Subject: Request for Comment on Cabramatta Rail Loop – extended exhibition period (SSI 9186)

EES has reviewed the response to submissions prepared by ARTC undated and provide the following comments:

Appendix C – Impact Mapping

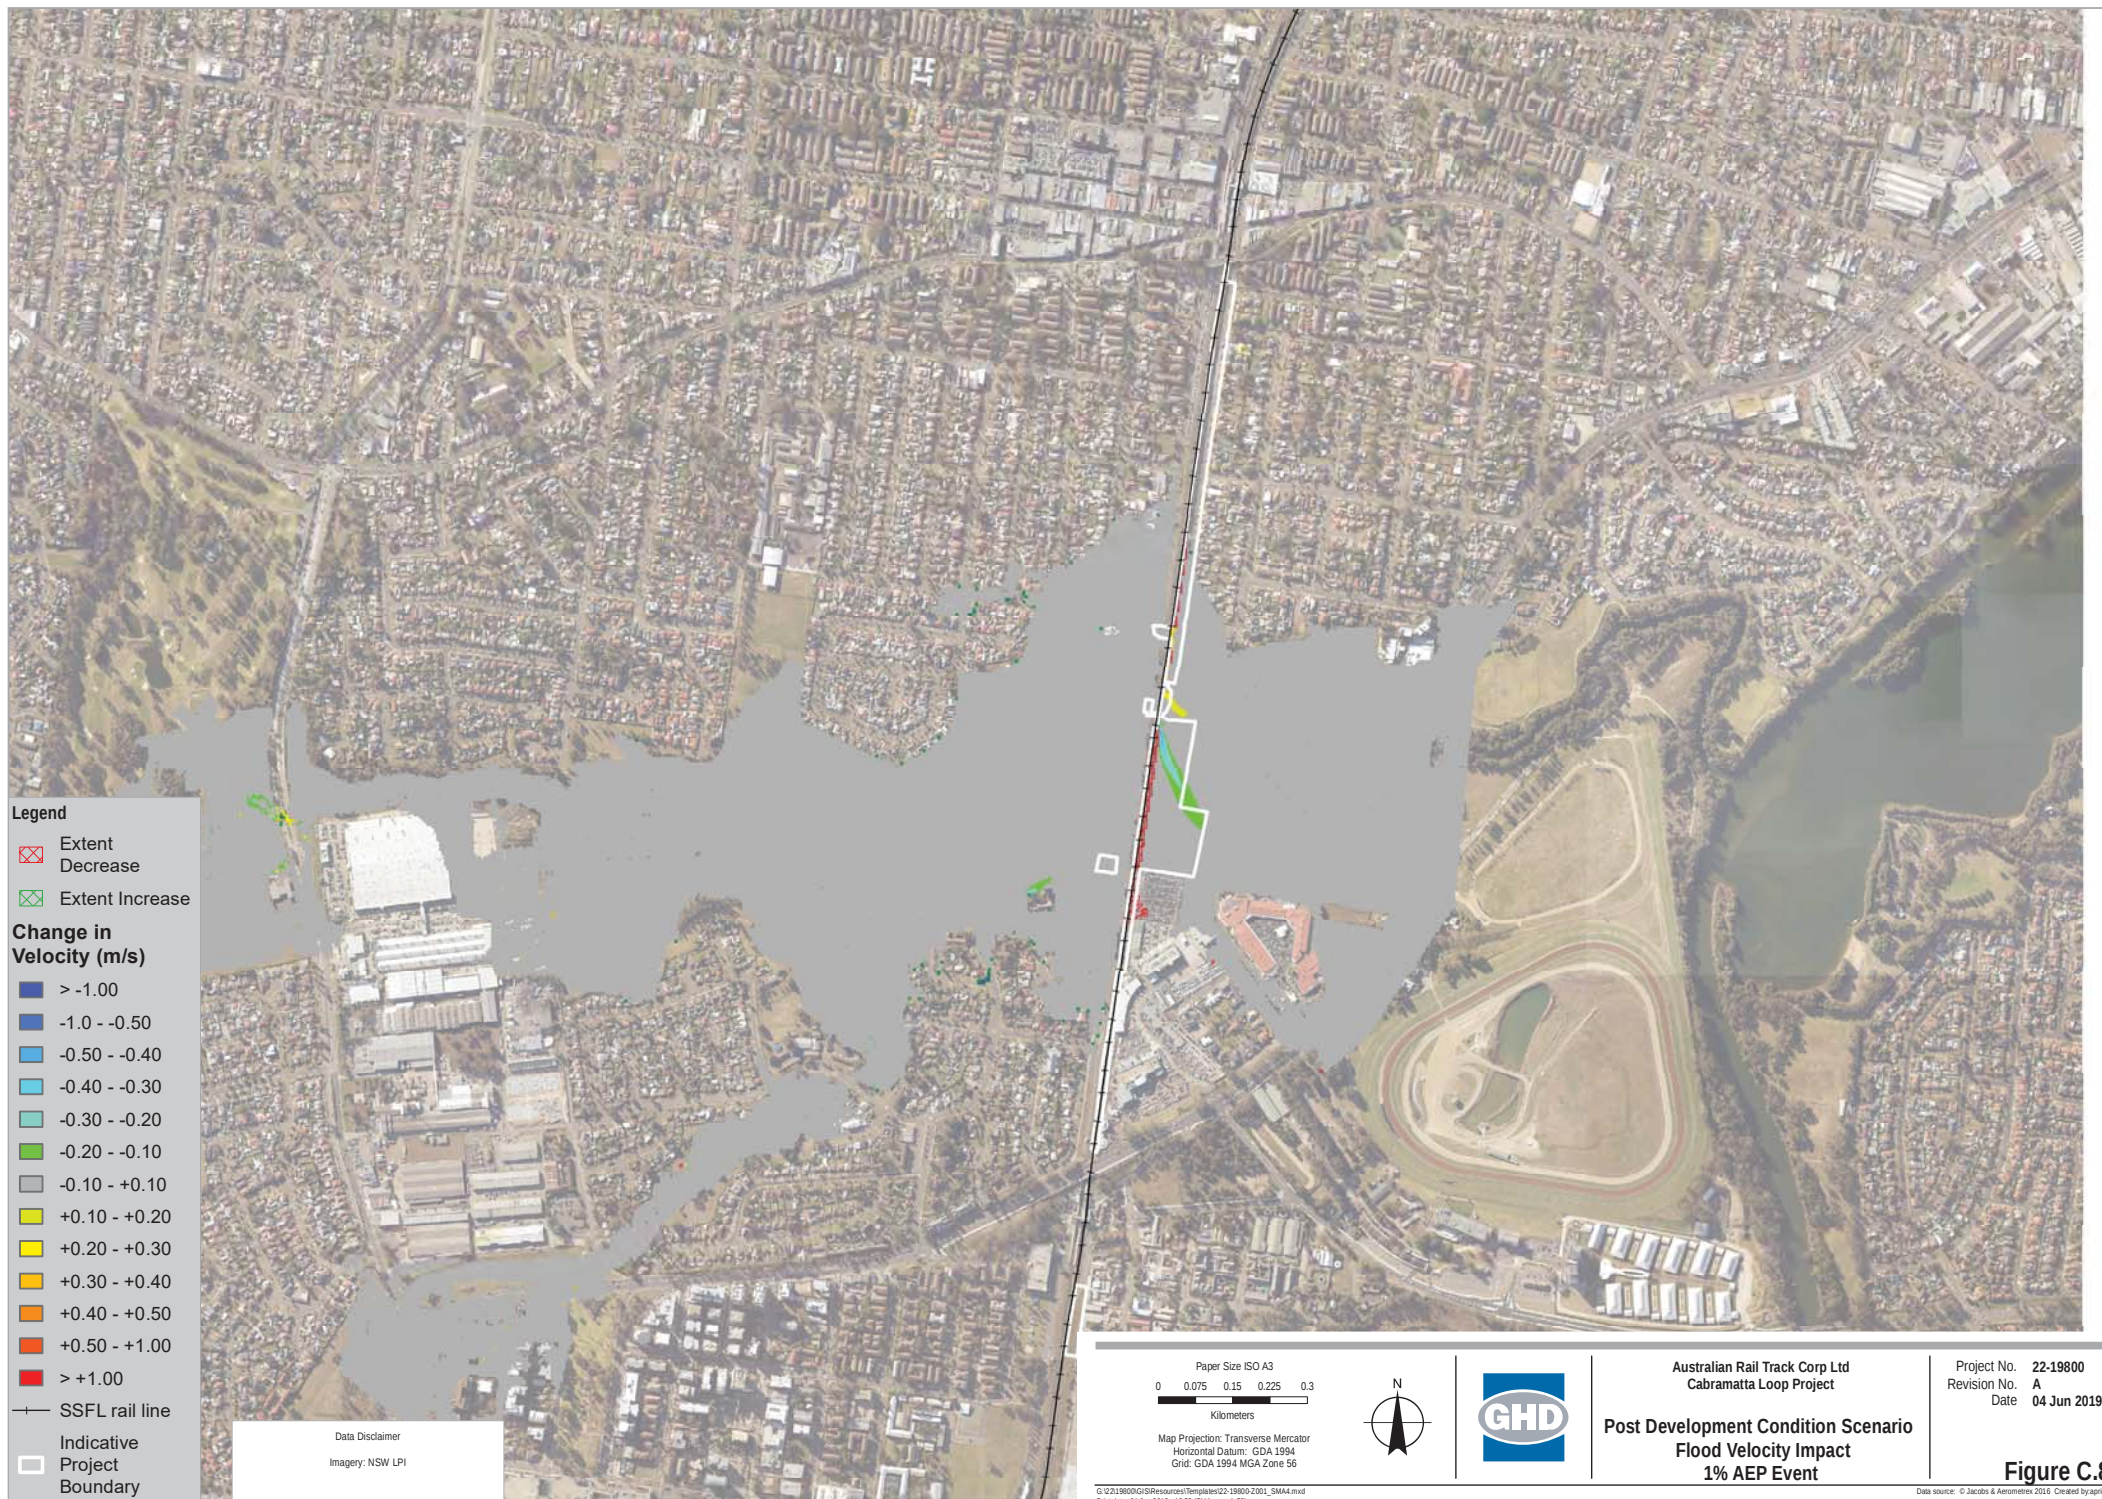
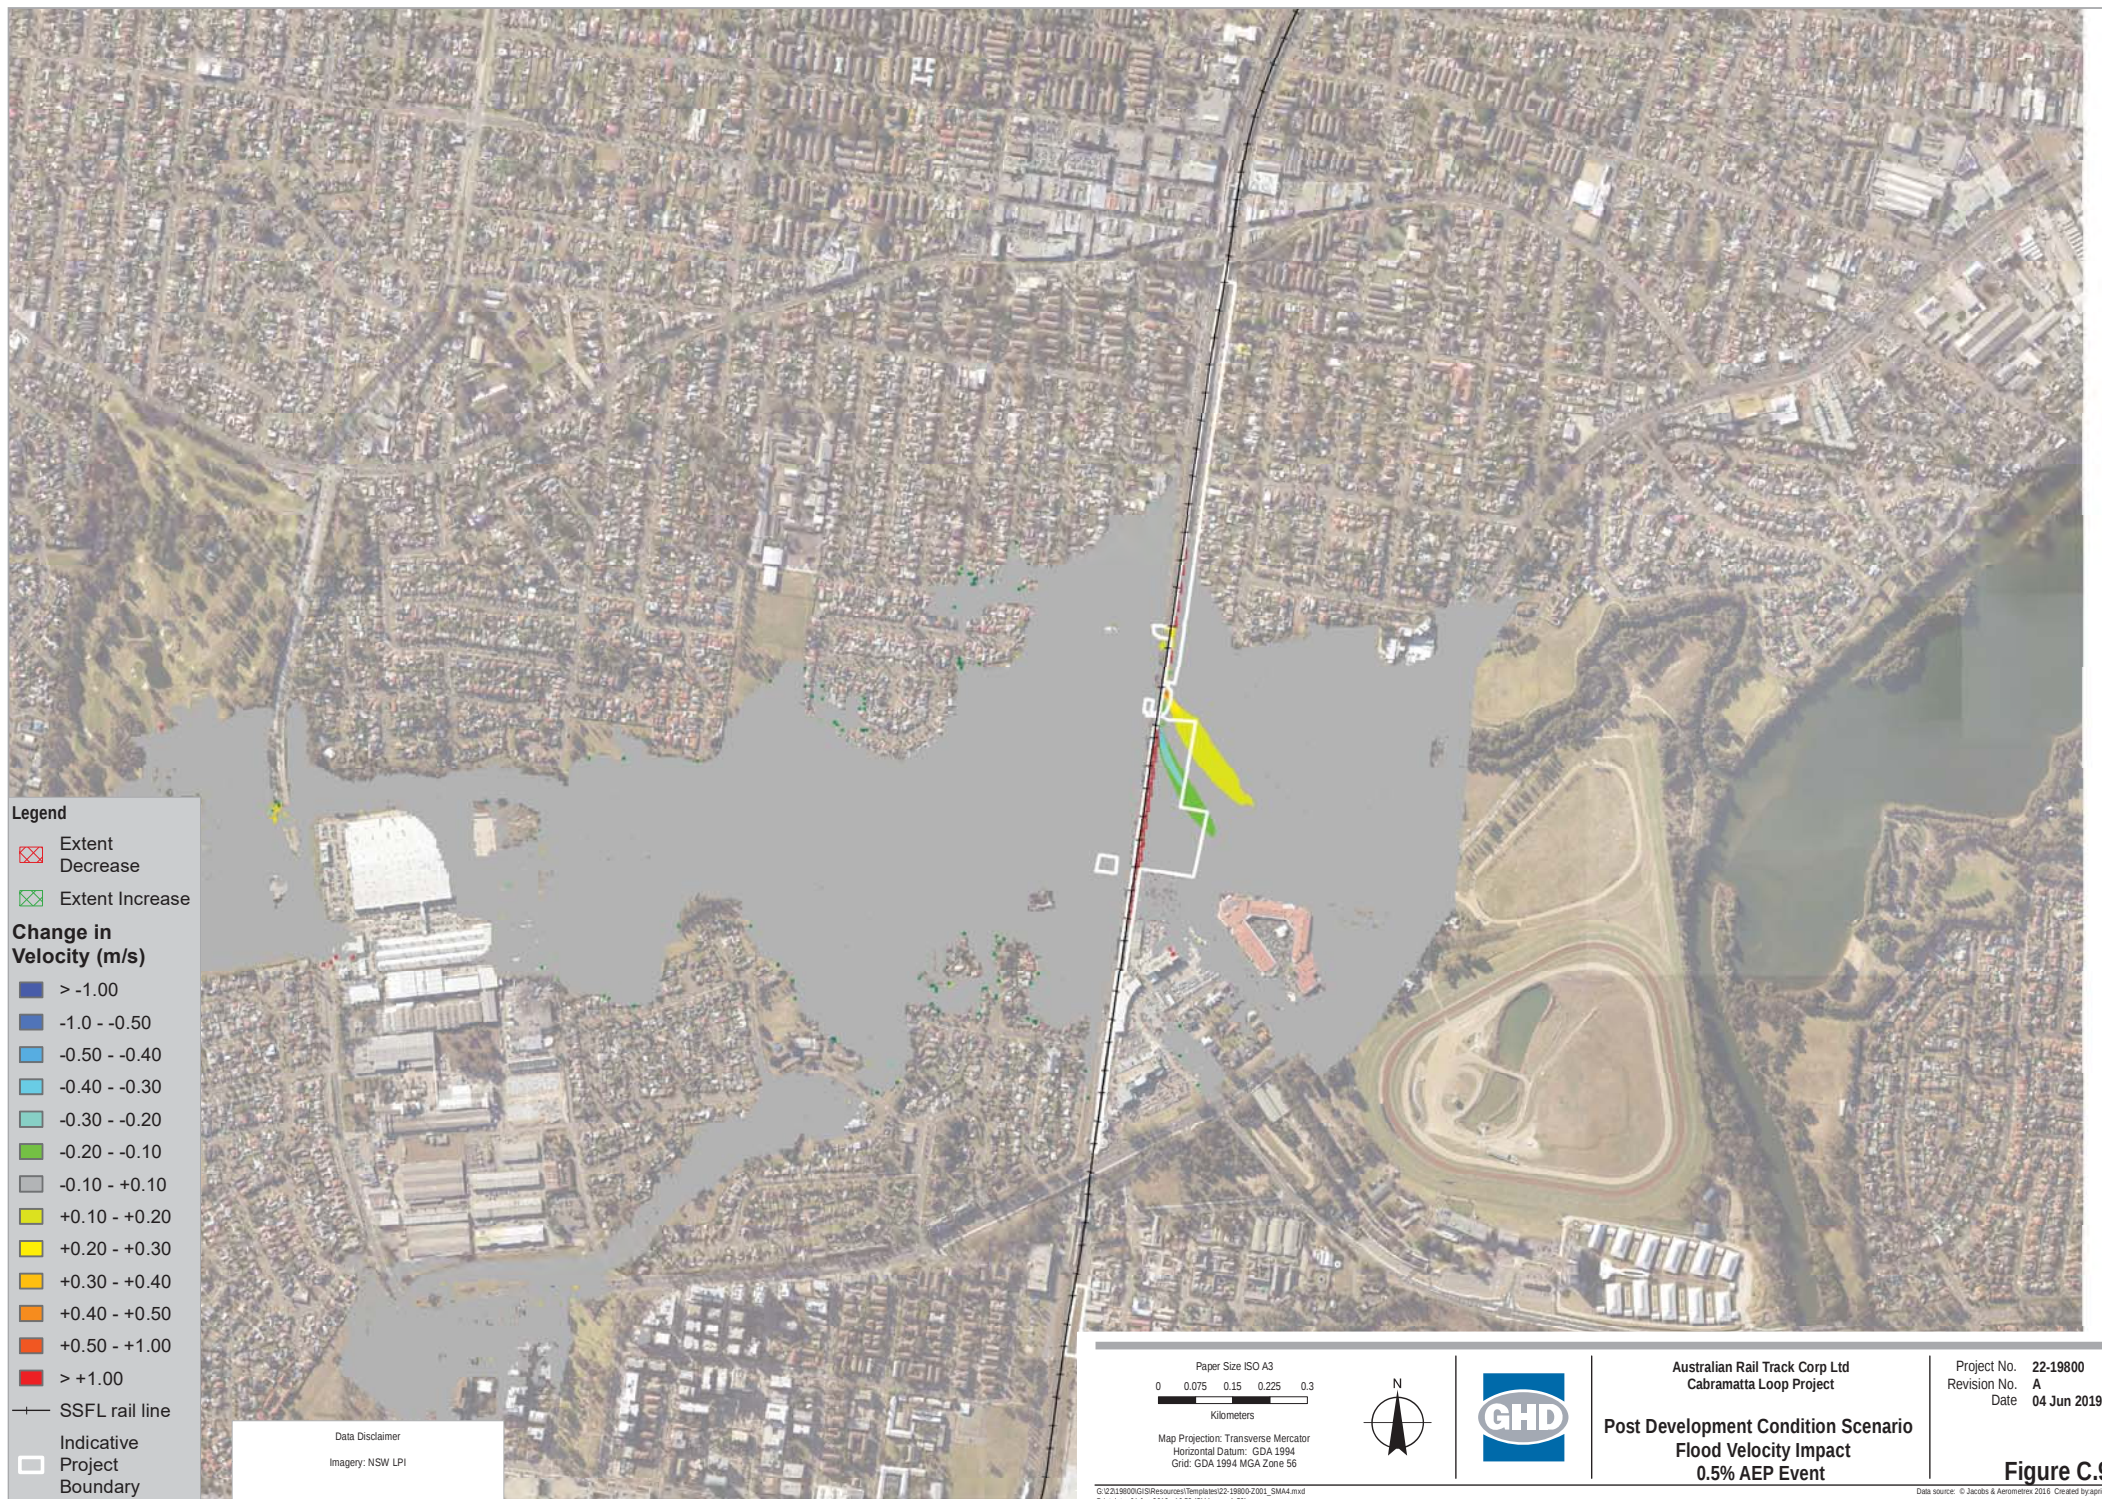
The flood maps should include the changes in flood depths within the Bloomfield Street Catchment with and without infrastructure development (i.e. difference of flood levels) for a range of events to evaluate flooding impacts and the development of appropriate mitigation measures.
